SPR EA1N and EA2 PROJECTS

DEADLINE 2 - COMMENTS ON EXQ1 RESPONSES - 1.18 TRAFFIC & TRANSPORT

Interested Party: SASES

Question	Topic	Question	Response	SASES Comment
1.18		Transportation and Traffic		
		ES Chapter 26 Traffic and Transport [APP-074]		
1.18.2	A12/ A1094 Friday Street junction	Both SCC as highway authority and ESC as LPA raise concerns in their RRs [RR-002, 007] about the following matters: - abnormal loads; - the mitigation measures proposed at the A12/A1094 Friday Street junction (40mph speed limit southbound on A12, rumble strips, repositioning of speed camera – a new roundabout is suggested); - the lack of planning obligations; - cumulative impacts; - the scoping out of operations, maintenance and decommissioning activities; - traffic movements; - mitigation compromising other schemes eg Sizewell C; and - Protective Provisions for SCC access as highway authority for inspection and maintenance. • Please exp	The Applicants are engaging with the Councils to address their concerns through the development of the Statement of Comment Ground (SoCG) (submitted at Deadline 1). To inform this process a series of clarification notes have been / are being prepared. Traffic a

TITLE
 SWEEP PATH ANALYSIS
 A1094/B1122 ROUNDABOUT

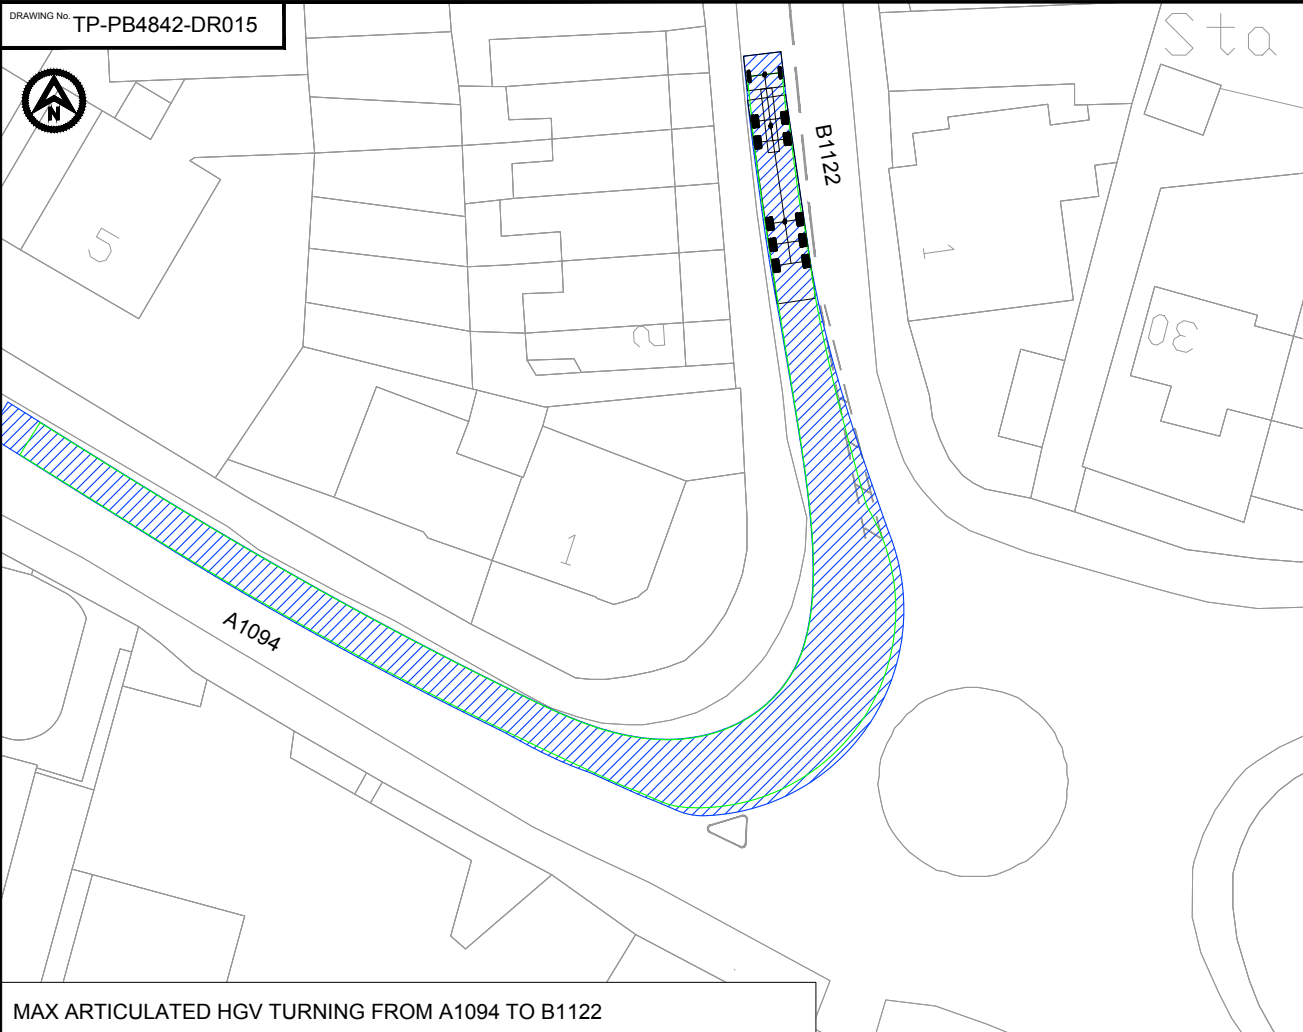
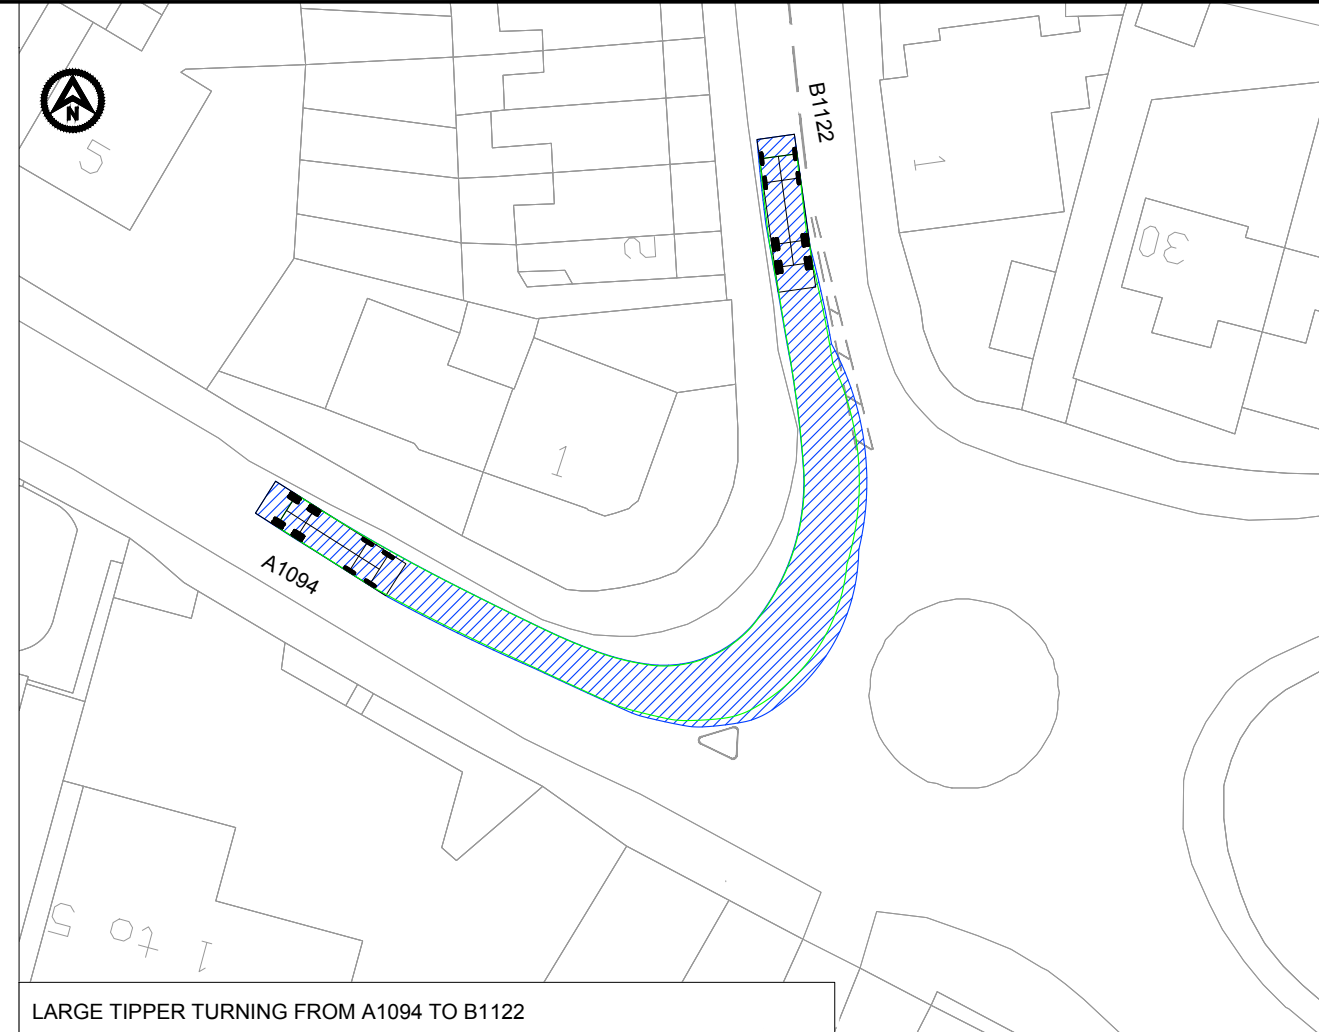
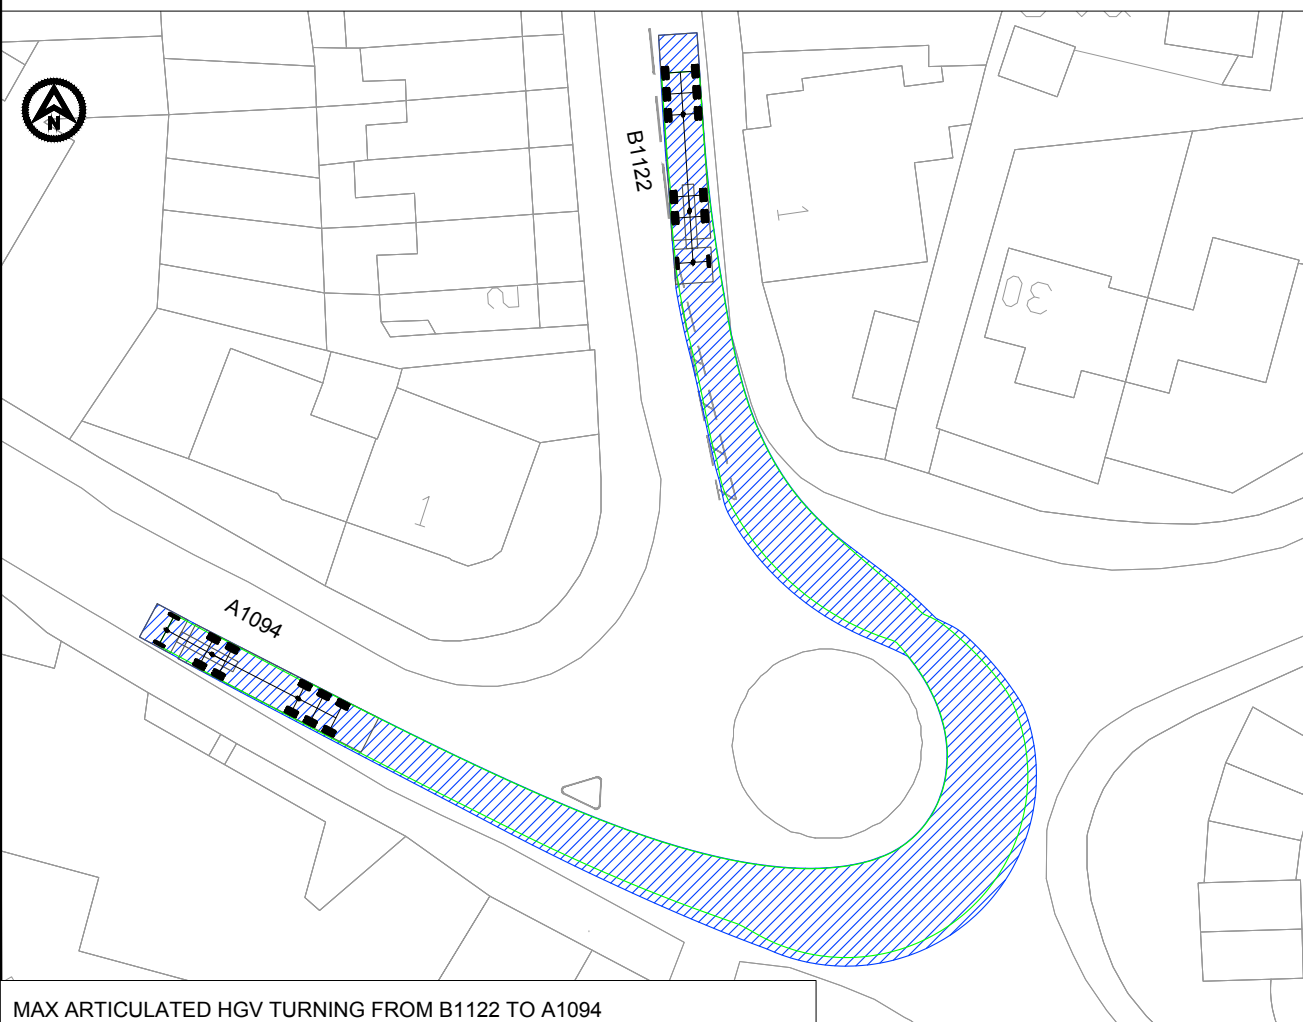
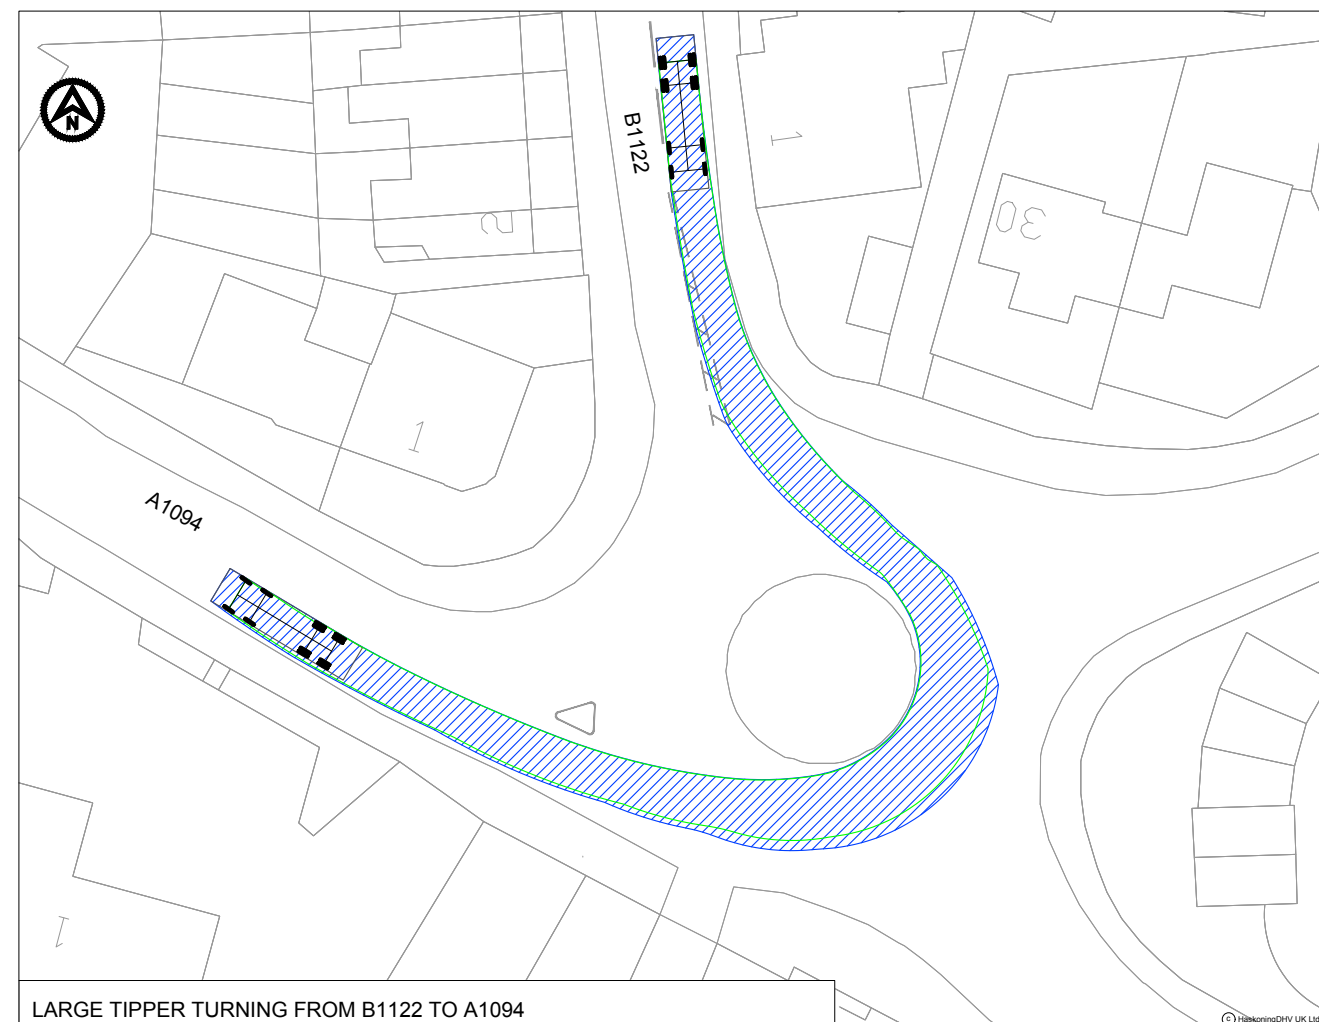
1.18.51 SPR's response to the ExA request for an explanation of why the use of a pilot vehicle is considered adequate mitigation regarding path blocking by site traffic at the roundabout junction of the A1094 and B1122 is flimsy when the real difficulty is the ever present narrowness of the B1122 and several hundred metres of street parking, as local residents will confirm.

<p>pilot vehicle would run ahead of the vehicle it is escorting. At the junction of the A1094 and B1122, the pilot vehicle would stop any oncoming traffic to allow the following HGV to pass any oncoming traffic.</p>	<p>number of parked cars both sides of the B1122 roundabout exit road outside houses without a garage or alternative parking spaces elsewhere could significantly compound congestion and delay at this junction. These issues have not yet been addressed within the OCTMP.</p>

SWEPT PATH ANALYSIS
 A1094 / B1069 JUNCTION

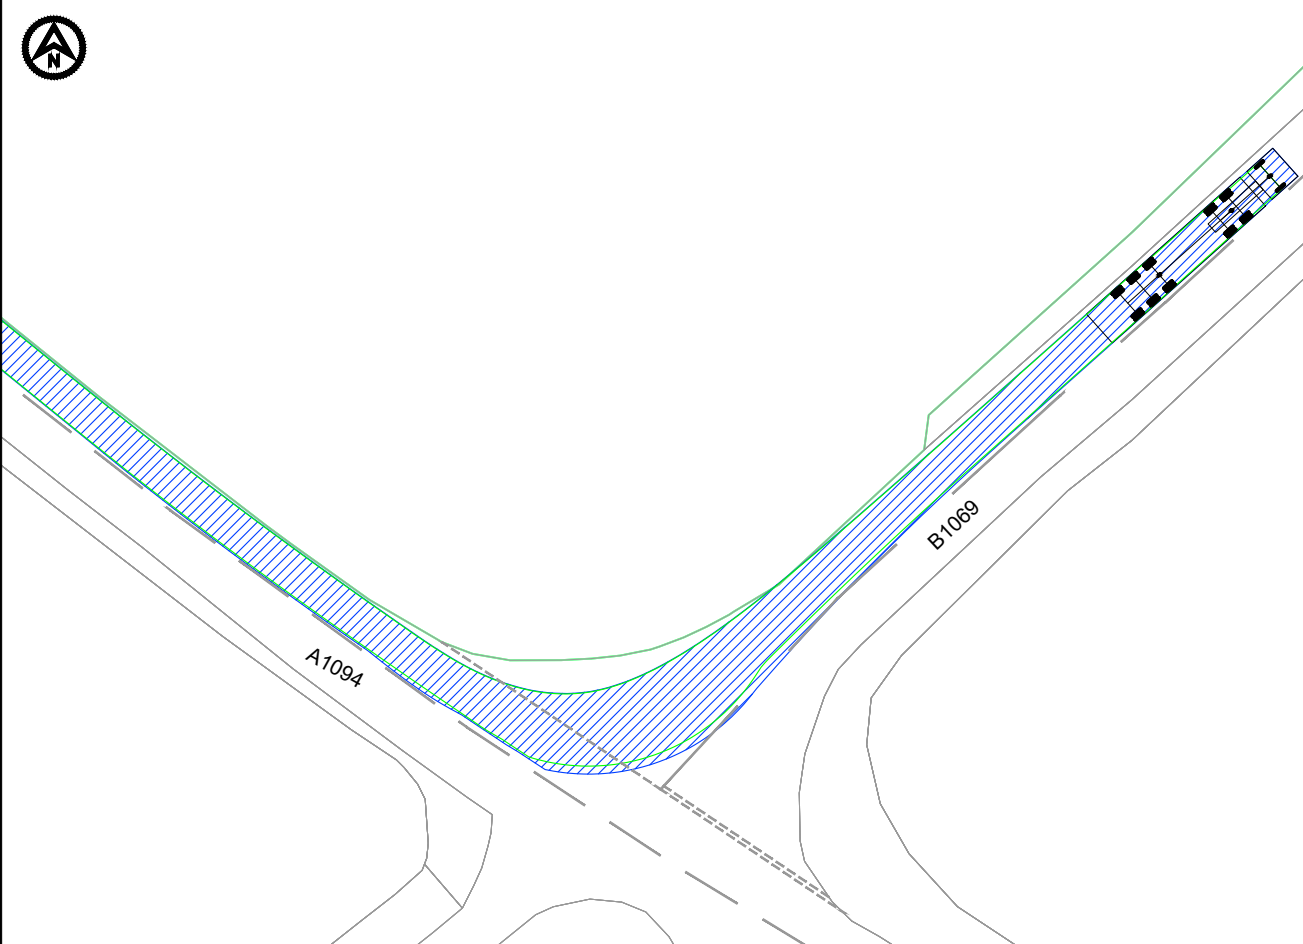
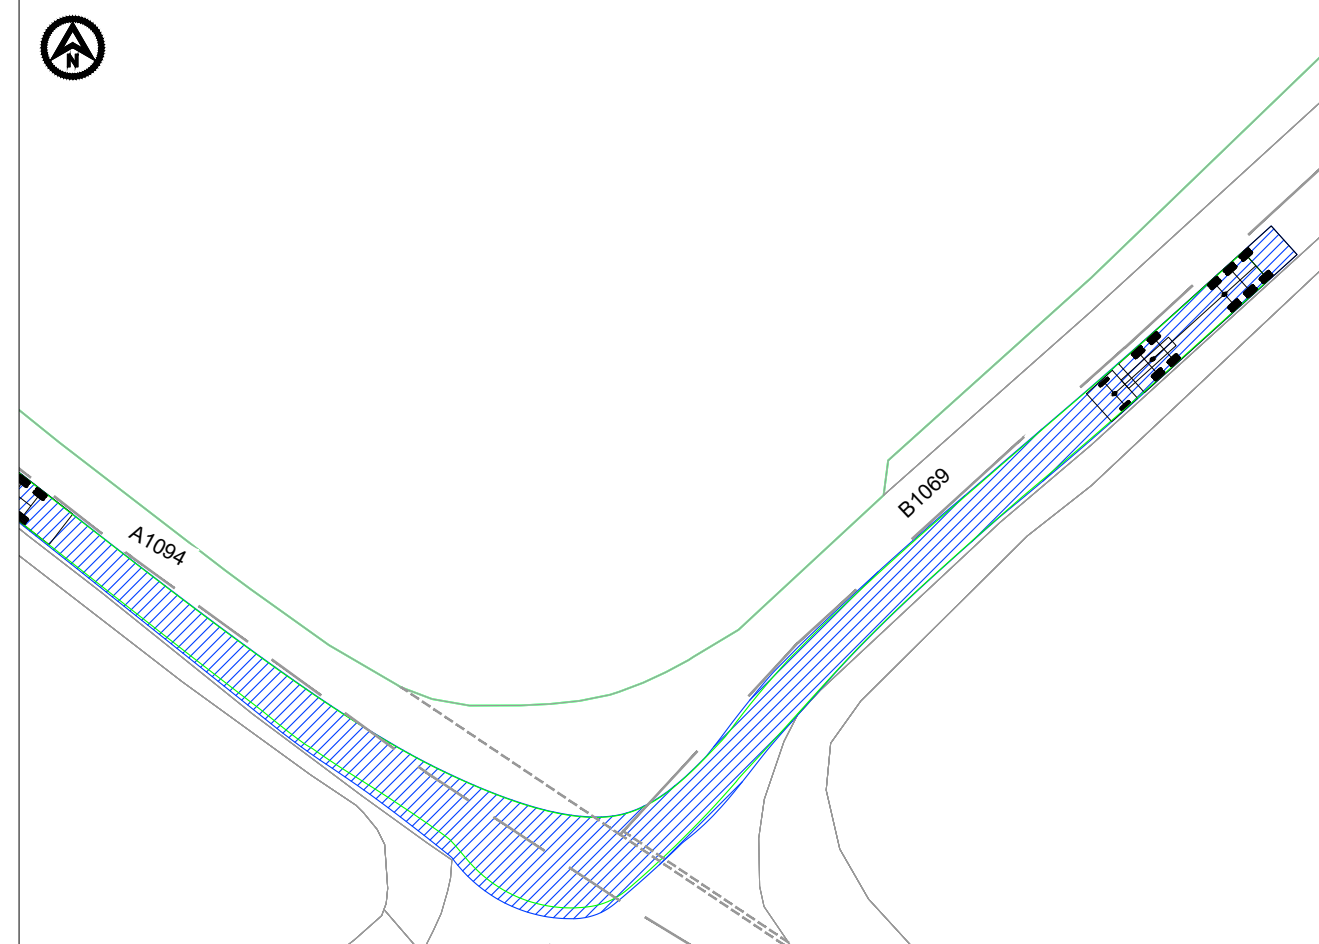
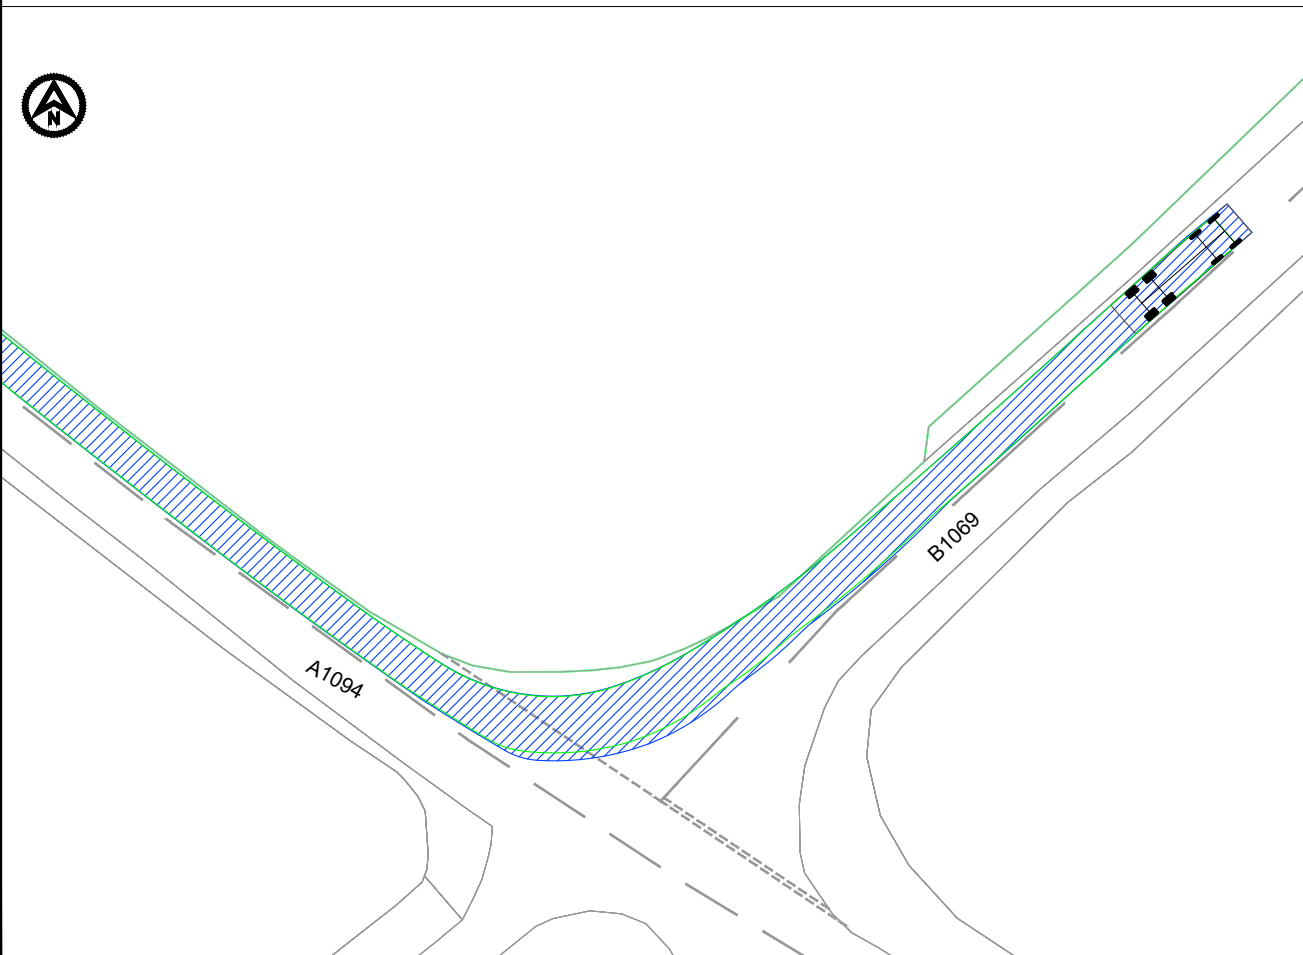
<p>of the B1069 Snape Road (not shown on the access to works plan).</p> <p>HGV volumes accessing links 5 and 6 at AC3 do not appear to justify a new 4-way 40 metres wide turning geometry at this road crossing ref. 8.10 Outline Access Management Plan- 'ACCESS 5 & 6 B1122 ALDEBURGH ROAD' [APP-587] since HGV traffic towards landfall is to travel via Sizewell Gap Road.</p> <p>The Applicant's response to ExQ 1.18.39 b) does not explain the relevance of its swept path analysis of HGVs turning between the A1094 and B1069 to three options currently being considered for access to section 3B.</p>

<p>b) explain what you mean by “appropriately sized vehicles”.</p>	<p>swept path analysis of HGVs turning between the A1094 and B1069 has been undertaken. The analysis presented within Appendix 26.21 (APP-547) demonstrates that a rigid body tipper HGV could complete this manoeuvre, but an articulated HGV would over-sail into the opposite lane. In this regard, an appropriately sized vehicle would therefore be one that could make this turn without oversailing into the opposite lane, such as a rigid body tipper.</p>	<p>IS AT THE CENTRE OF ALDRINGHAM, MIDWAY BETWEEN THE NORTH AND SOUTH BOUNDARIES OF PARISH BOUNDARIES.</p> <p>The Applicant has provided no justification for failing to commit to submit a consistent plan for access to cable route section 3B.</p> <p>Clarity from the Applicant is required at this stage in the Examination.</p> <p>6.1.26 Table 26.22 [APP-074], 6.2.26.2 Environmental Statement - figure 26.2 [APP-307], paragraph 211 of the Environmental Statement [APP-074] and 8.10 Outline Access Management Plan Table 2.1 [APP-587] indicate that only a small length of section 3 will be served by AC3 temporary exits west and east off B1122 Aldeburgh Road, Aldringham and that most of this section would be served by an access west</p>
